DELEGATED DETAILS DECISION

Report of the Head of Planning, Building Control, Sport & Green Spaces

Address GOLDEN CROSS BOTWELL LANE HAYES

LBH Ref Nos: **4607/APP/2014/3648**

Drawing No: 14.113.001 Revision: B

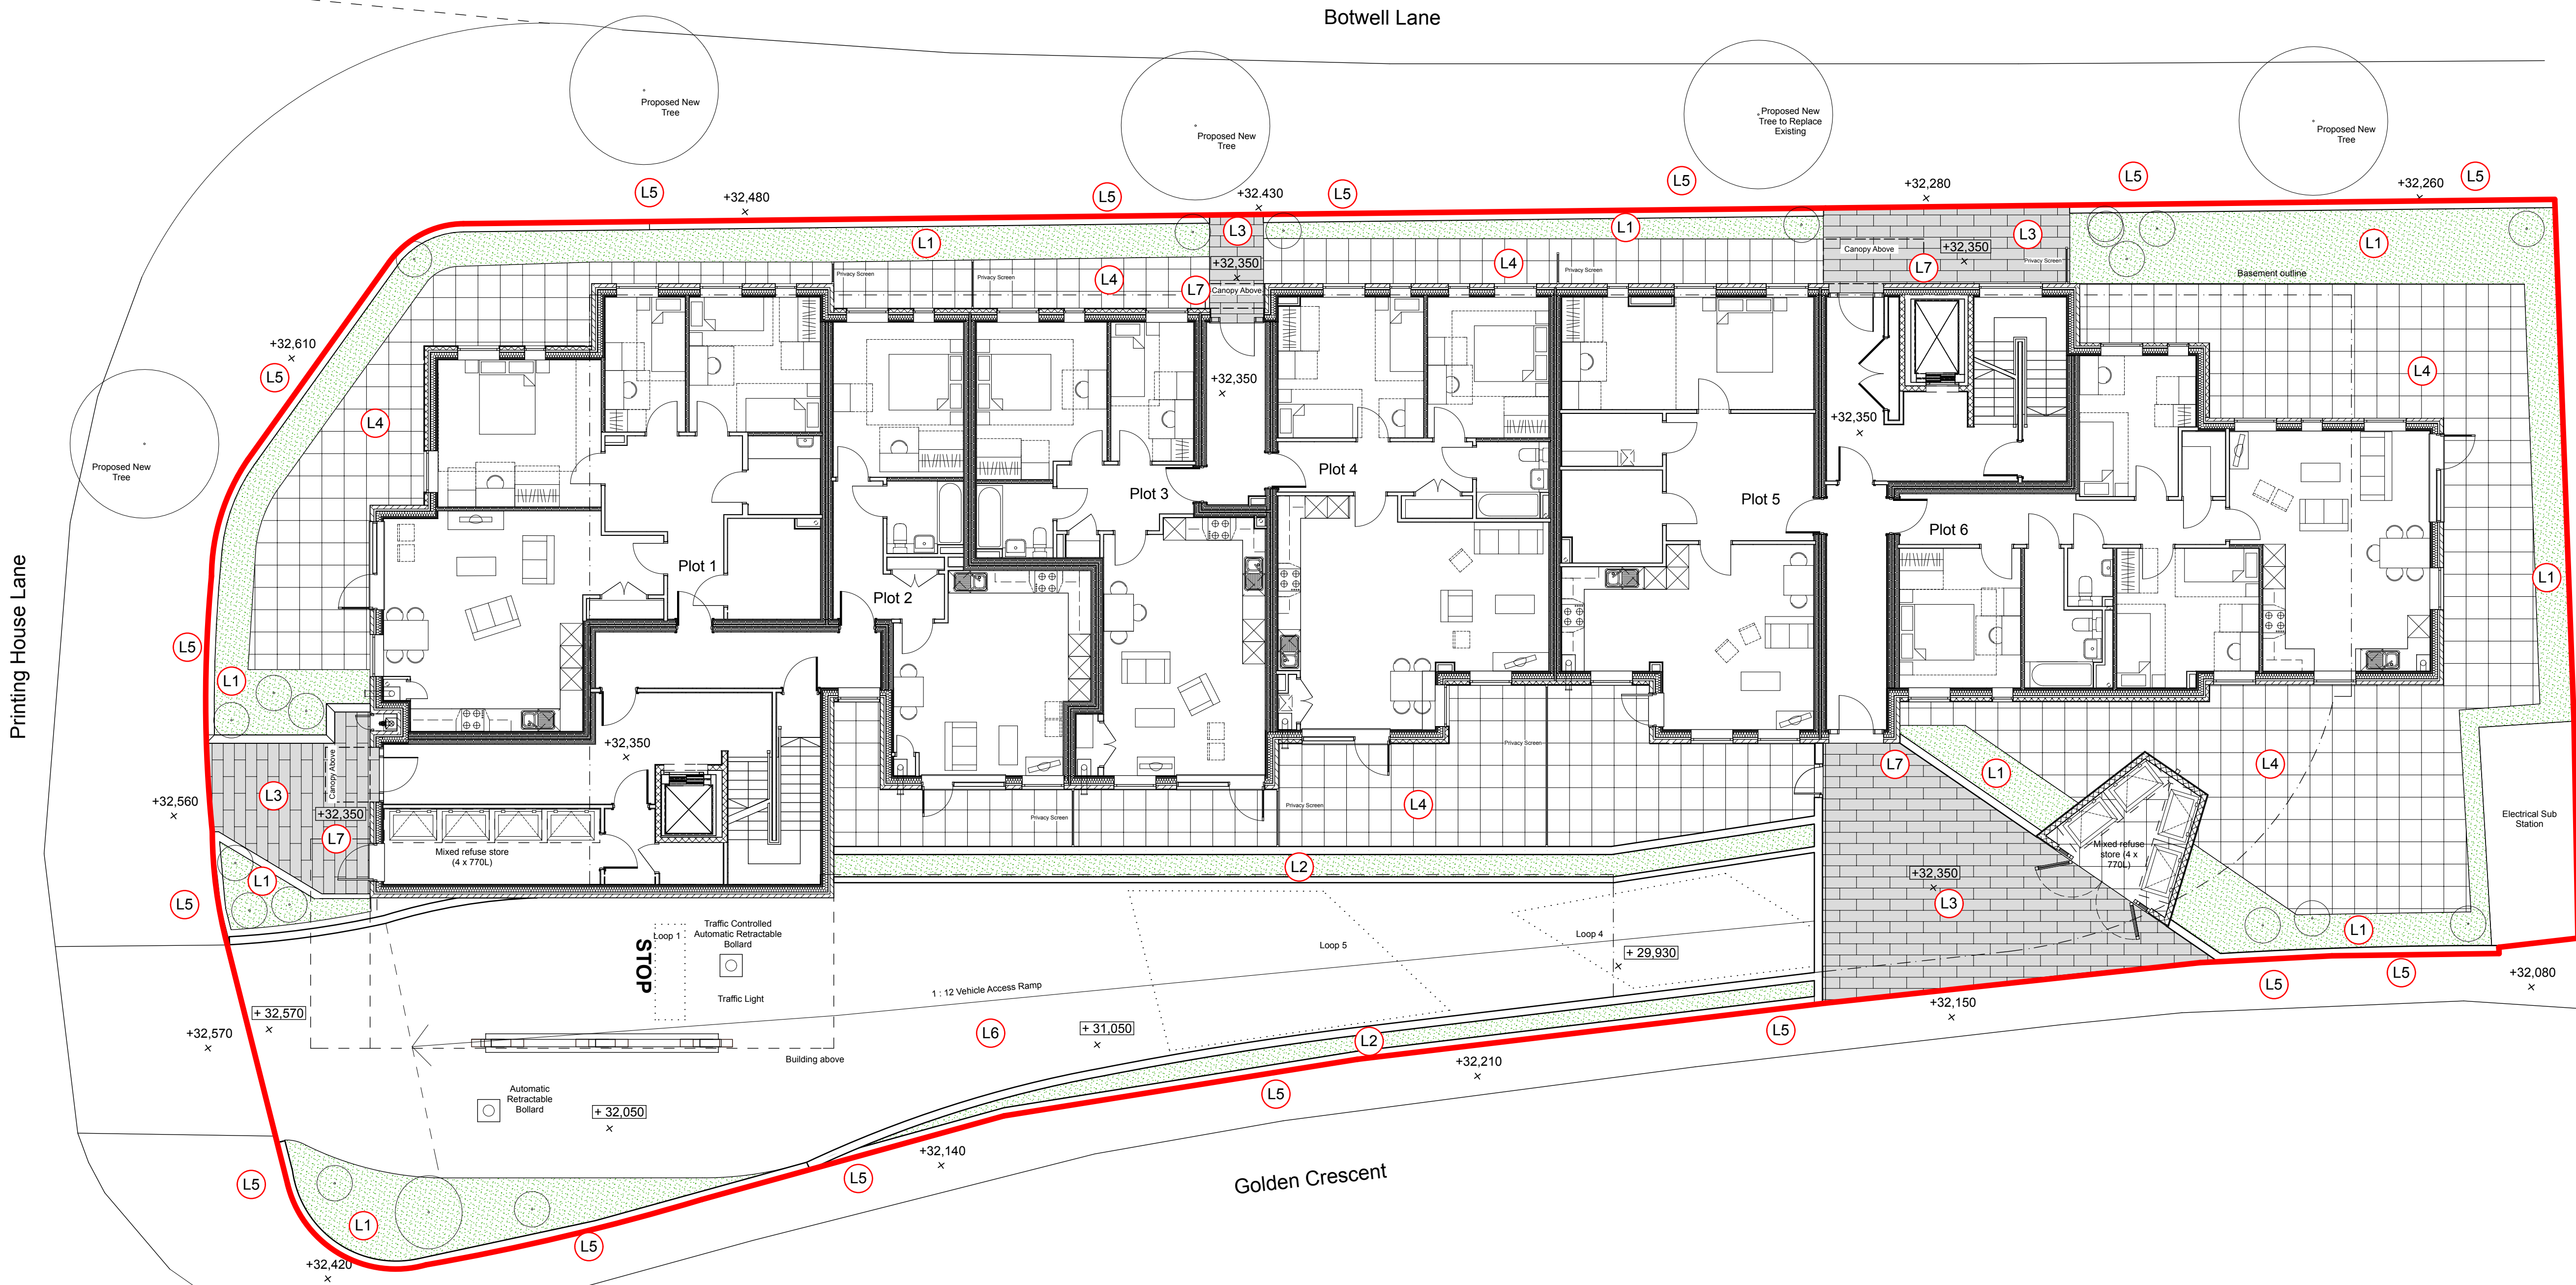
Existing off-site levels around the perimeter of the site are shown on PMC drawing No. 14.113.001 Rev B. This also provides the proposed paving levels relevant to the thresholds, the internal finished floor and the ramp to the underground car park.

No objection.

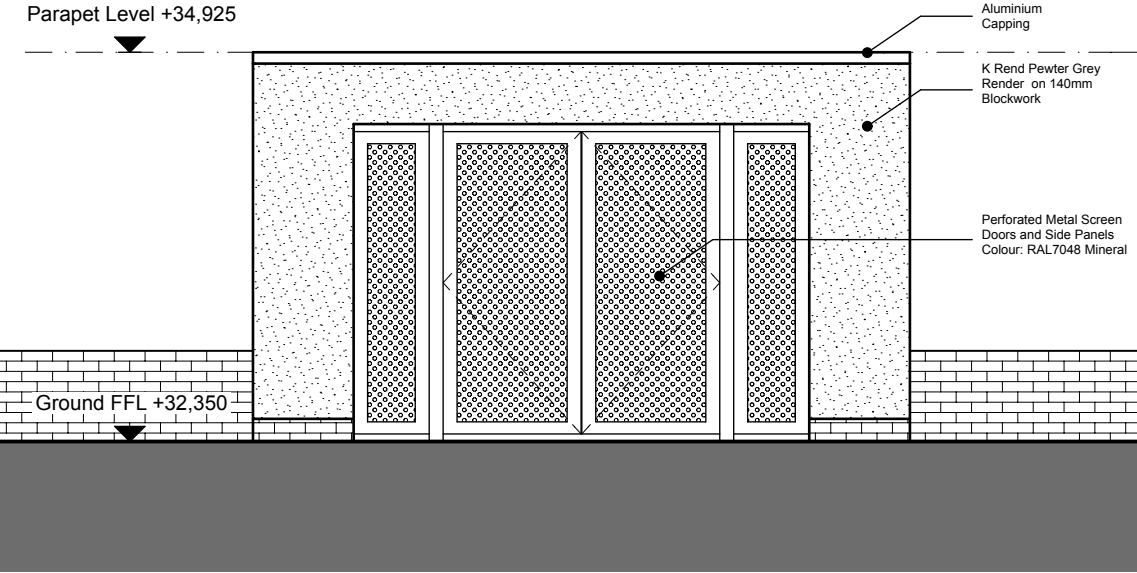
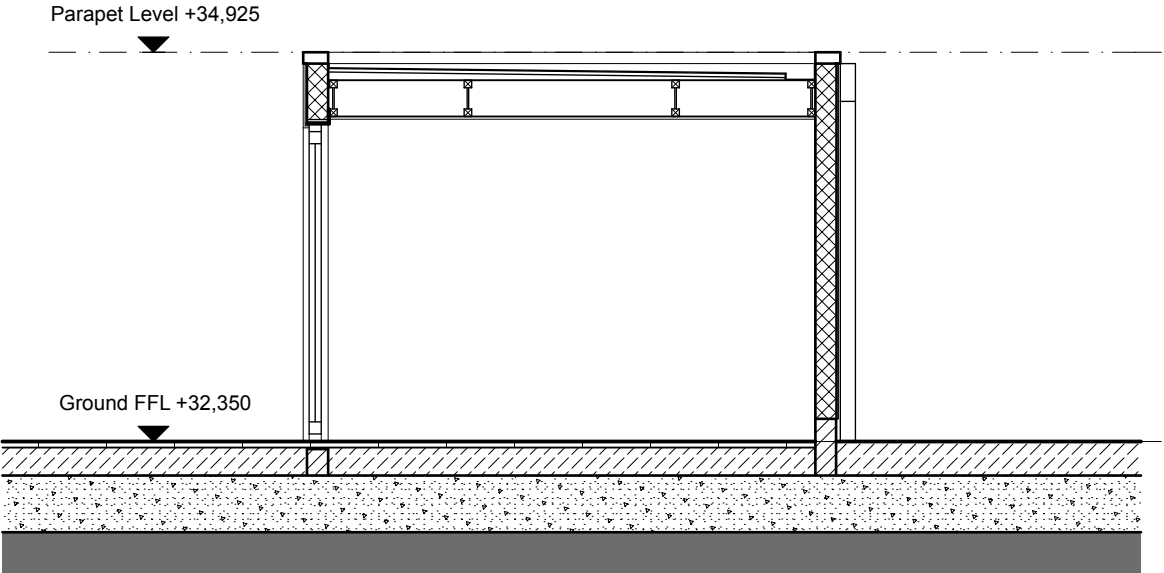
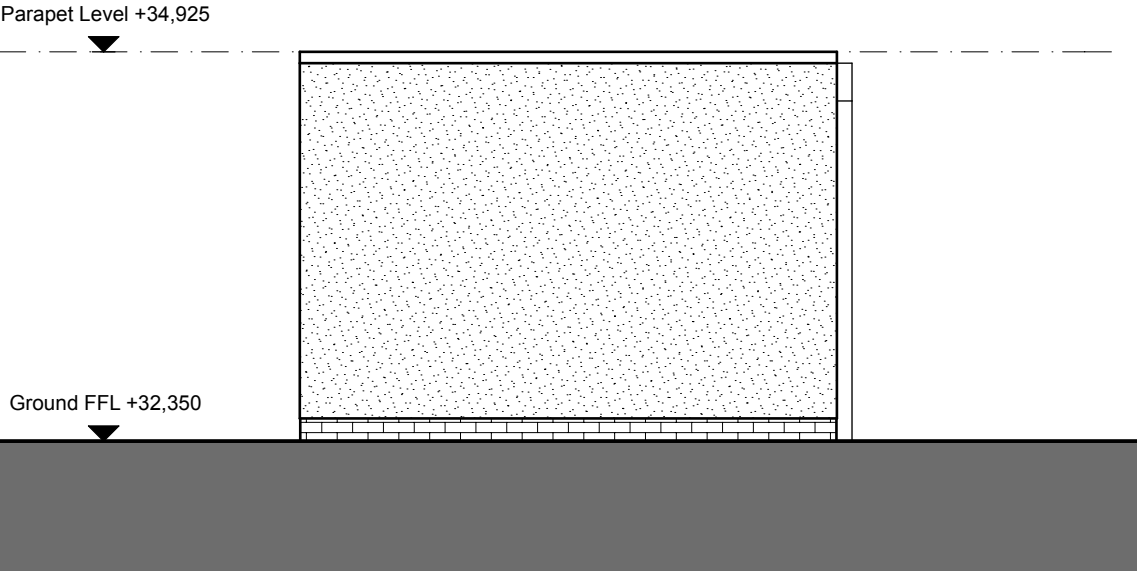
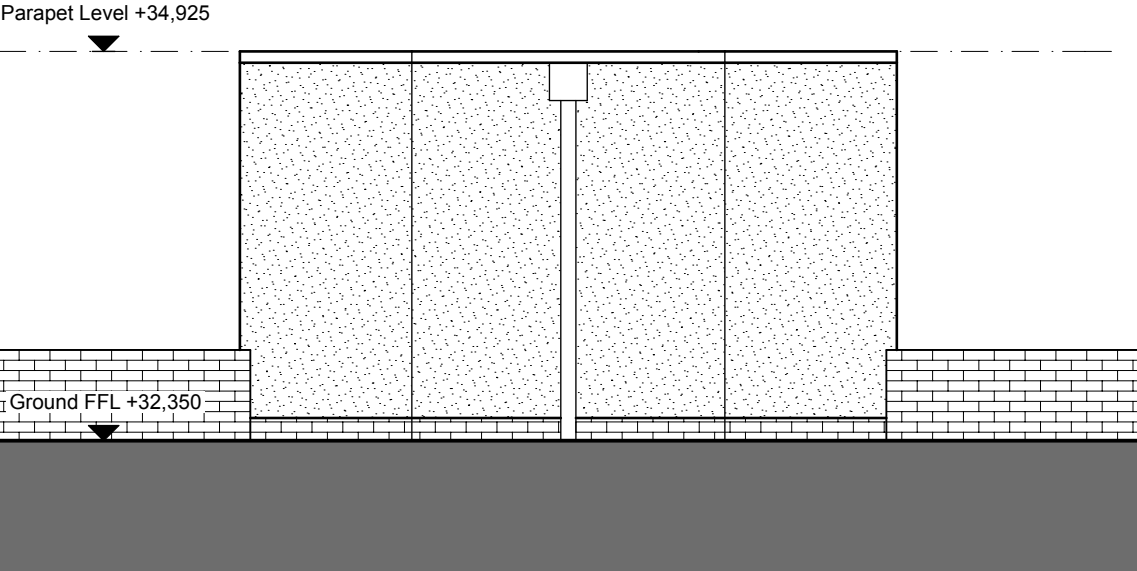
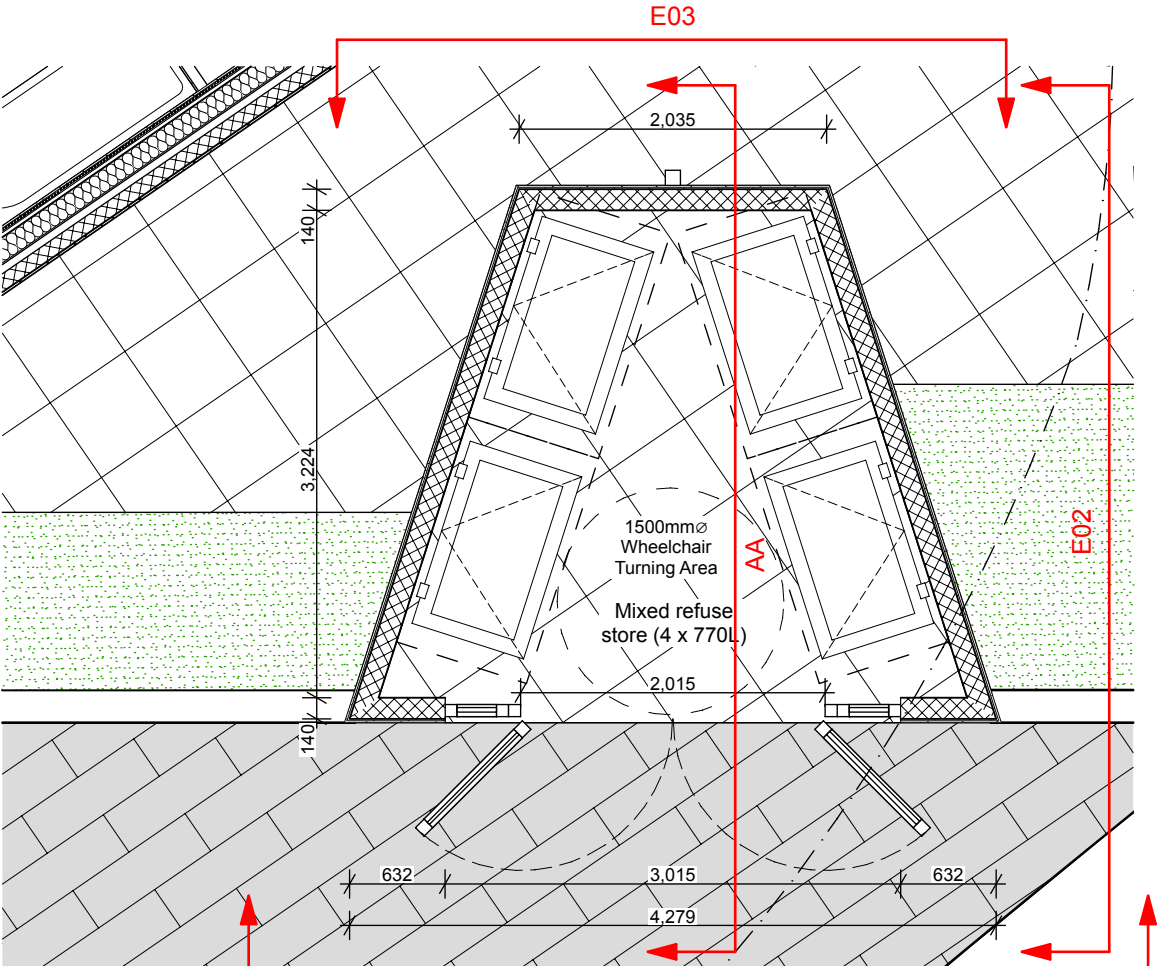
An exterior Bin Store Detail is provided on drawing No. 14.113.021. Elsewhere in the submission the Green Roofs & Walls Feasibility Study states that the bin store will be clad in green walls.

- Construction and planting details of the green walls should be specified together with the associated management and maintenance specification.

Drawing No
GHD2050 REV D

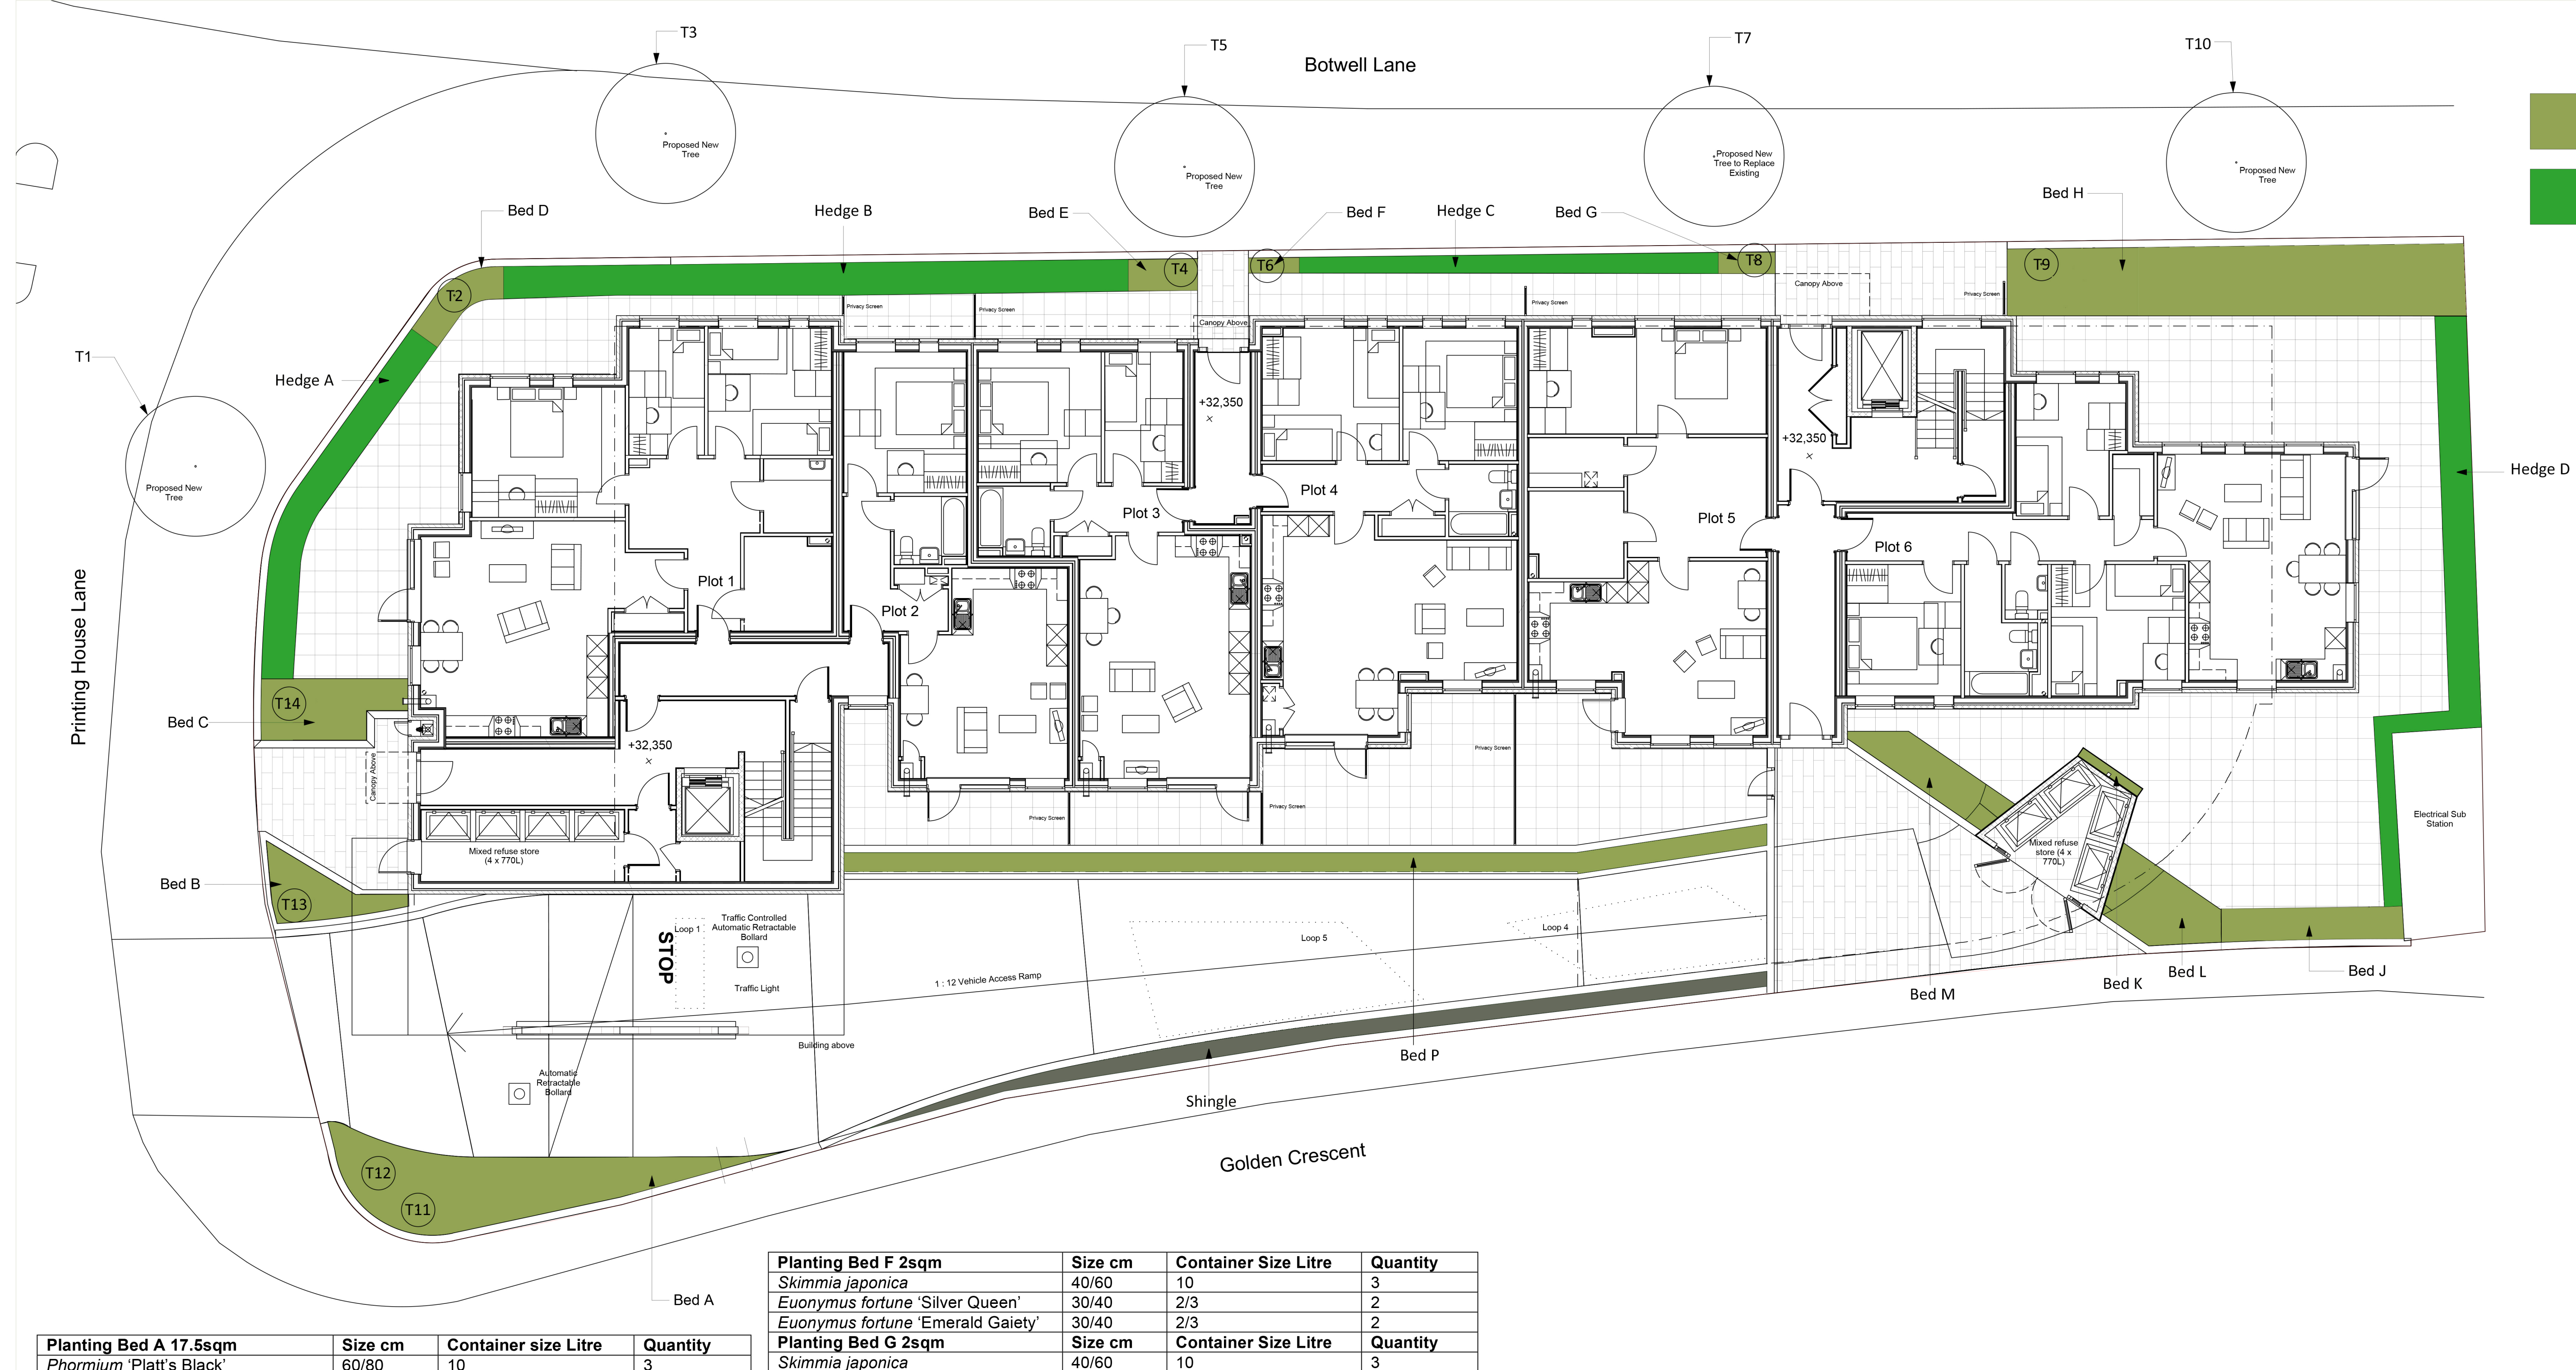
Thanks for this. The plan is now acceptable. As discussed, I am delighted (but surprised) to see street tree planting shown on the plan. This was requested by me at the time of the original proposal but I was under the impression that it had not been funded.

You have pointed out that the street tree planting is specifically referred to in the planning approval.

It would be much easier if the Council's Tree Officer (John Bartlett) could arrange for the planting to ensure that the tree pit is adequately specified and appropriate tree selection made. Failing this, this Council will require further details regarding the tree pits, a larger size of tree at the time of planting and specifications from the developer.

As regards condition 5, revised details have been submitted which the Tree Officer advises are now satisfactory and more in line with the quality landscaping scheme envisaged with the original application. The Sustainability Officer also confirms that he is satisfied (with the exception of a living wall to a side of the bin store) that no living walls or roofs can be provided. As regards the tree planting on the highway being covered within the S106 Agreement, an informative highlighting this out has been attached.
